Recommendation Report for Works to Tree(s) on trees subject to a Tree Preservation Order (TPO)

REF NO: R/172/19/T

LOCATION: The Spires
Springfield Close
Rustington
BN16 2SZ

PROPOSAL: Various works to various trees.

Tree Retention and Protection Plan

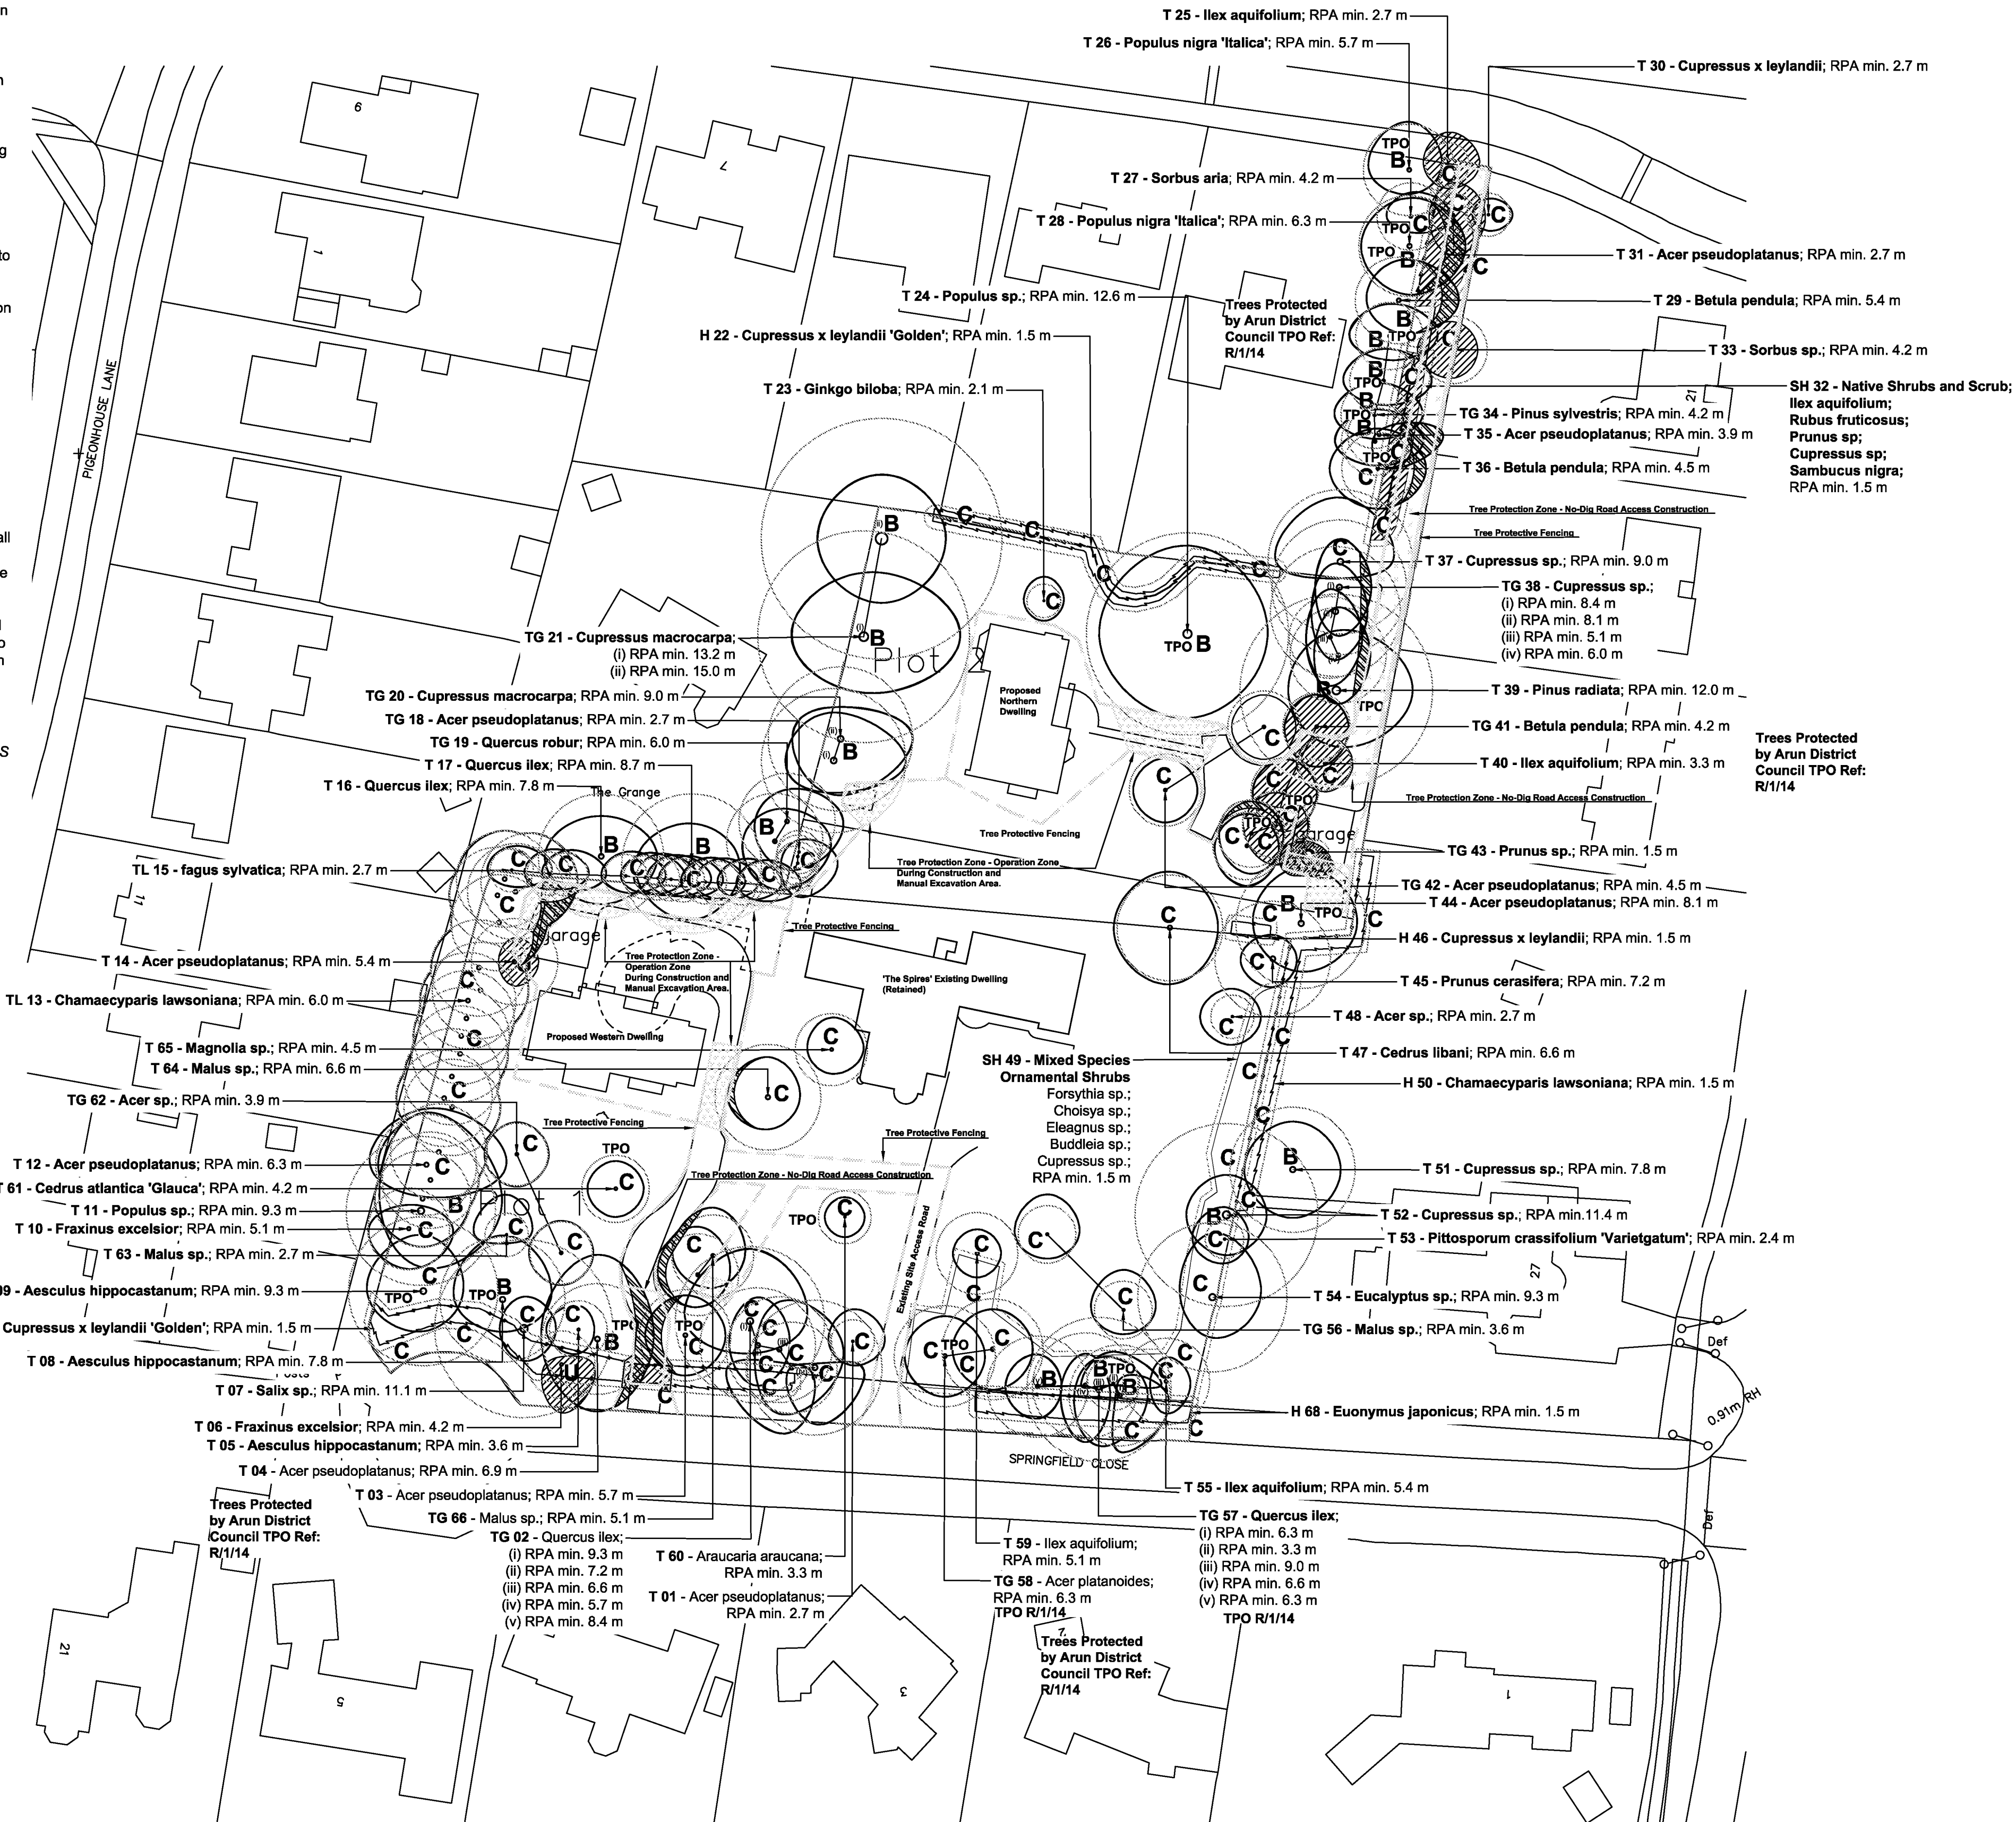
There are a number of individual and groups of trees included in this proposal. The work specification in the application form and trees shown on the supporting Tree Retention and Protection Plan (Lizard Landscape and Design, dwg. no. LLD1149 / 02, Rev. 01) were simultaneously considered during my site

The cardinal points quoted in respect of work proposals for TL15, T16 and T17 are confusing, although I assume from the specification that growth extending south into the plot is to be cut back by no more than 2.5m from its farthest extent. Such work is appropriate and would not be harmful to the health and vitality of these neighbouring trees. Exceeding this 2.5m limit would create unnecessarily large wounds and not be supported.

I recommend CONSENT for this application, subject to the following conditions
